CITY OF ALBUQUERQUE

September 6, 2018

Re: Chocolate Cartel
1218 San Pedro Dr. SE
30-Day Temporary Certificate of Occupancy- Transportation Development
Transportation Development Final Inspection
Architect's Stamp dated 08-10-17 (L18-D083)
Certification dated 08-30-18

SHEET
TCL
1 of 1

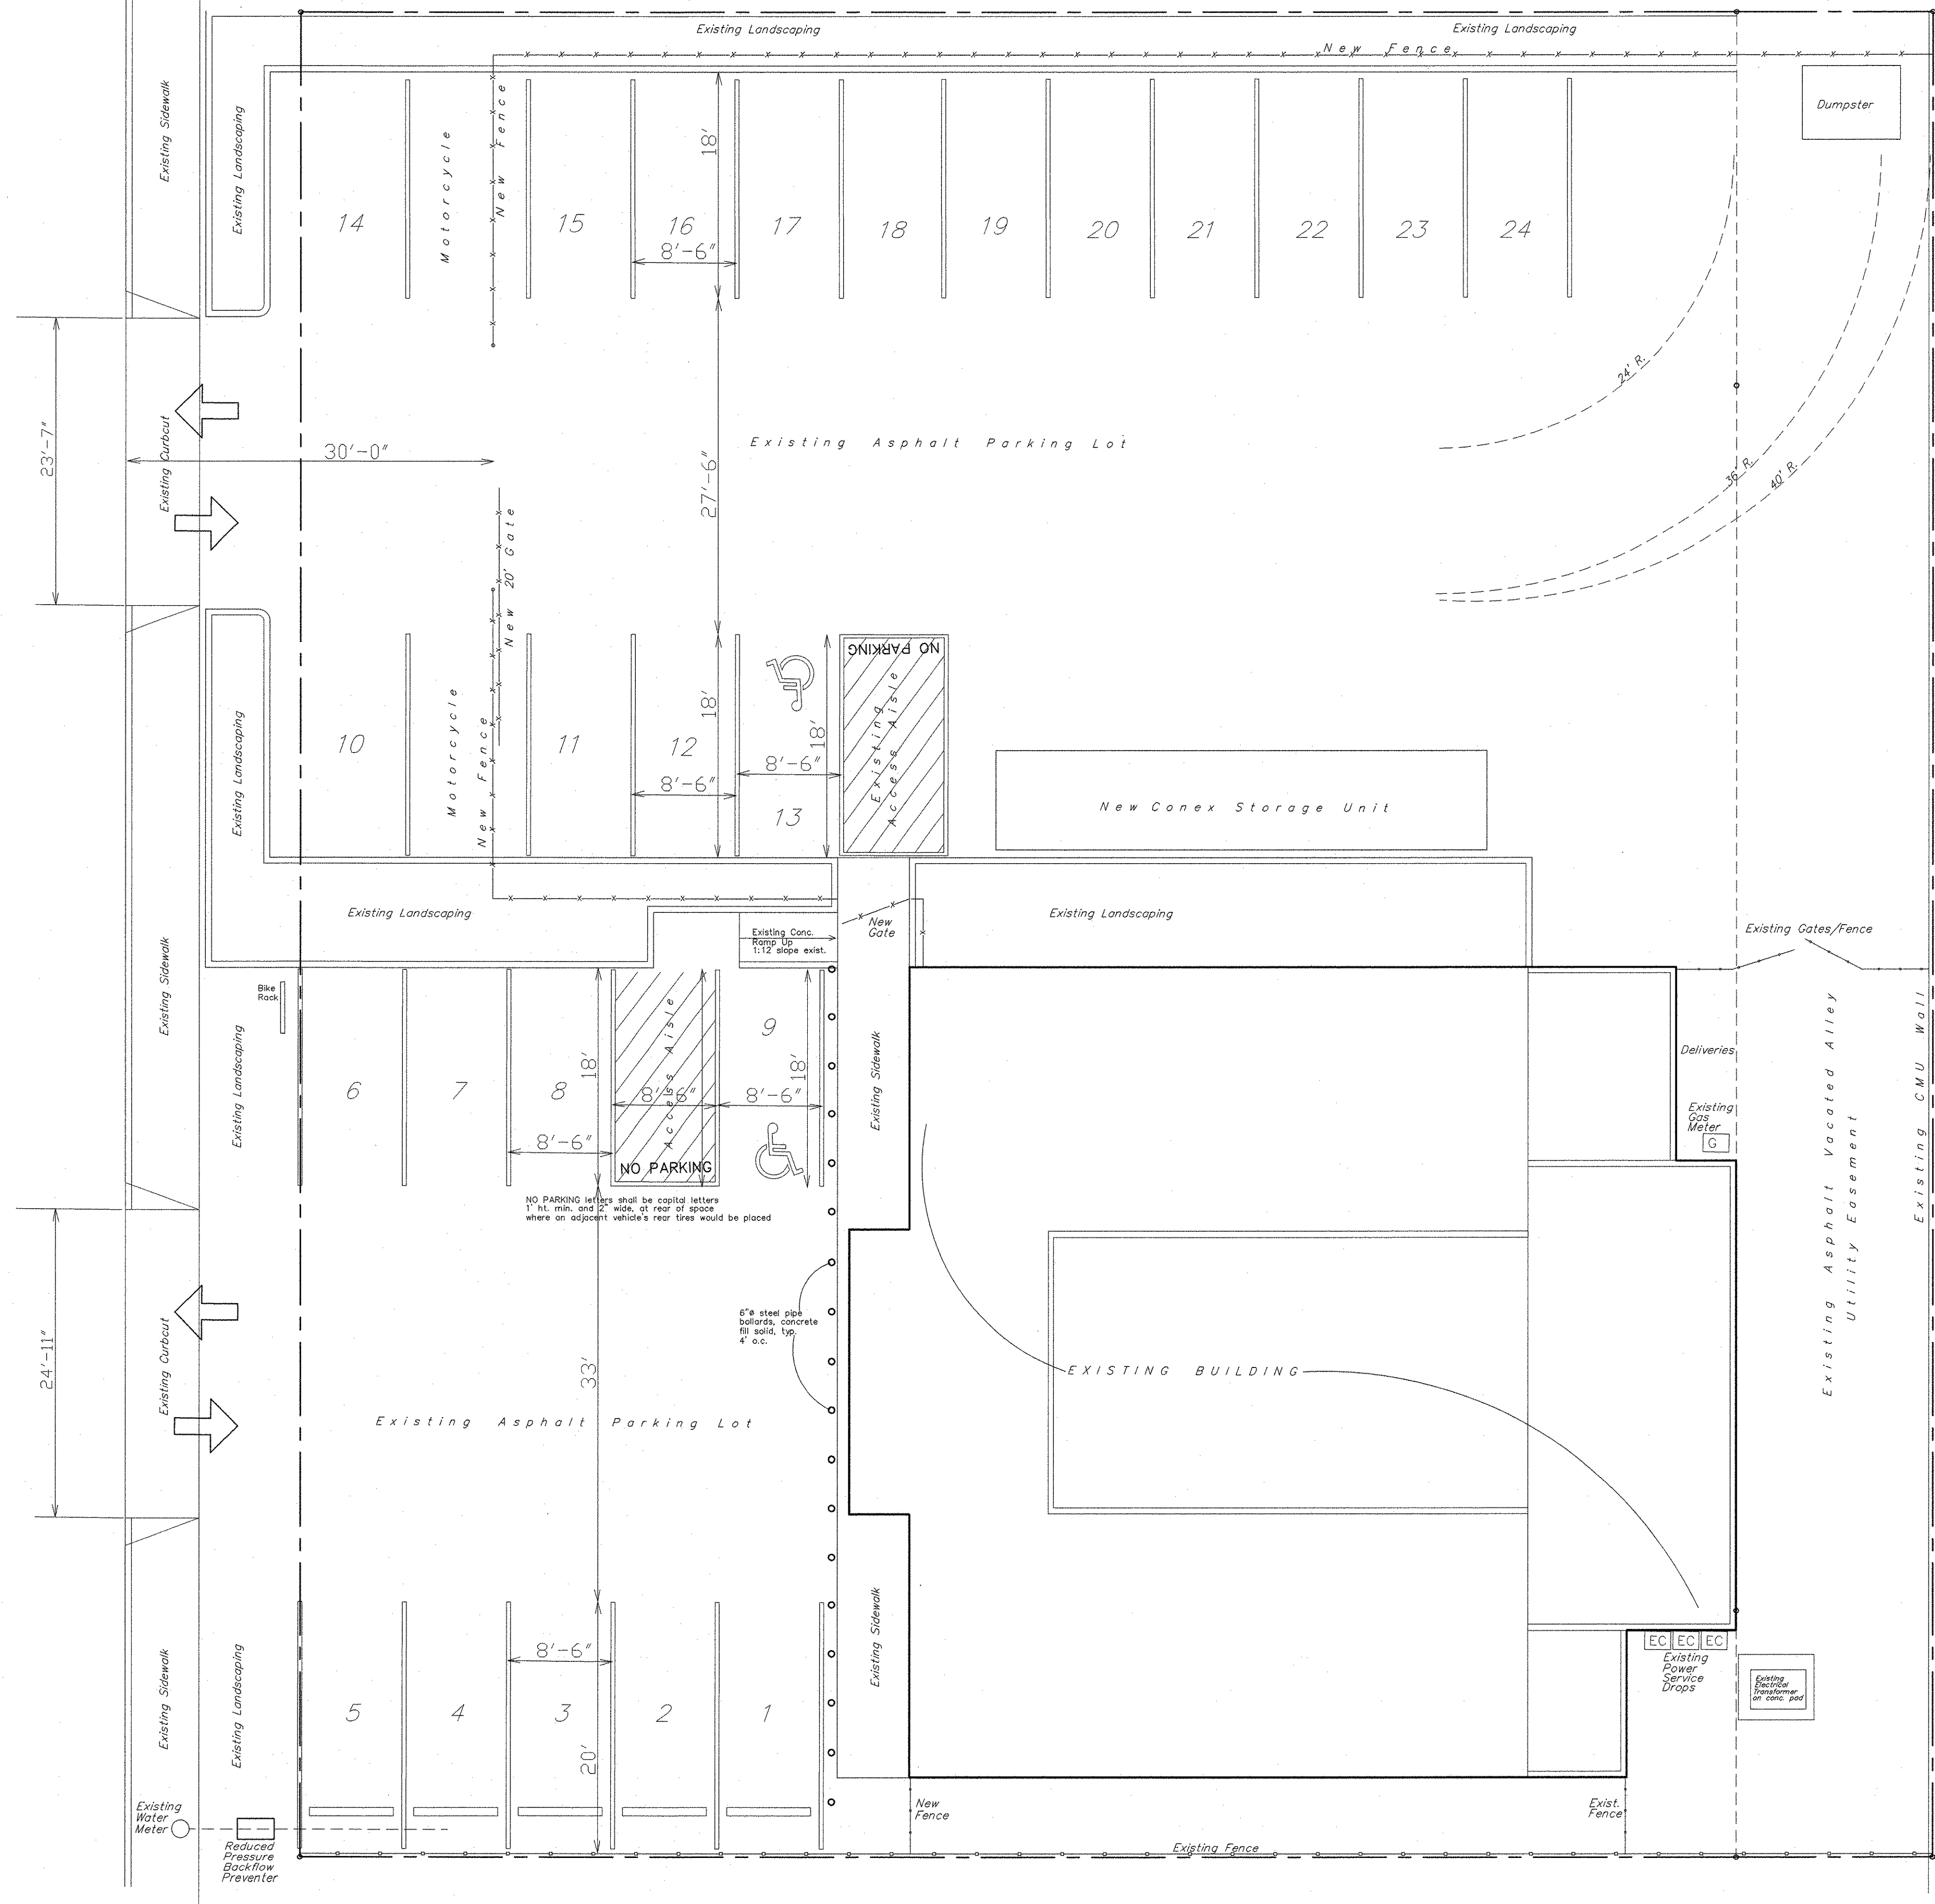
1. Motorcycle parking spaces shall be designated by its own conspicuously posted upright sign, either free-standing or wall mounted.
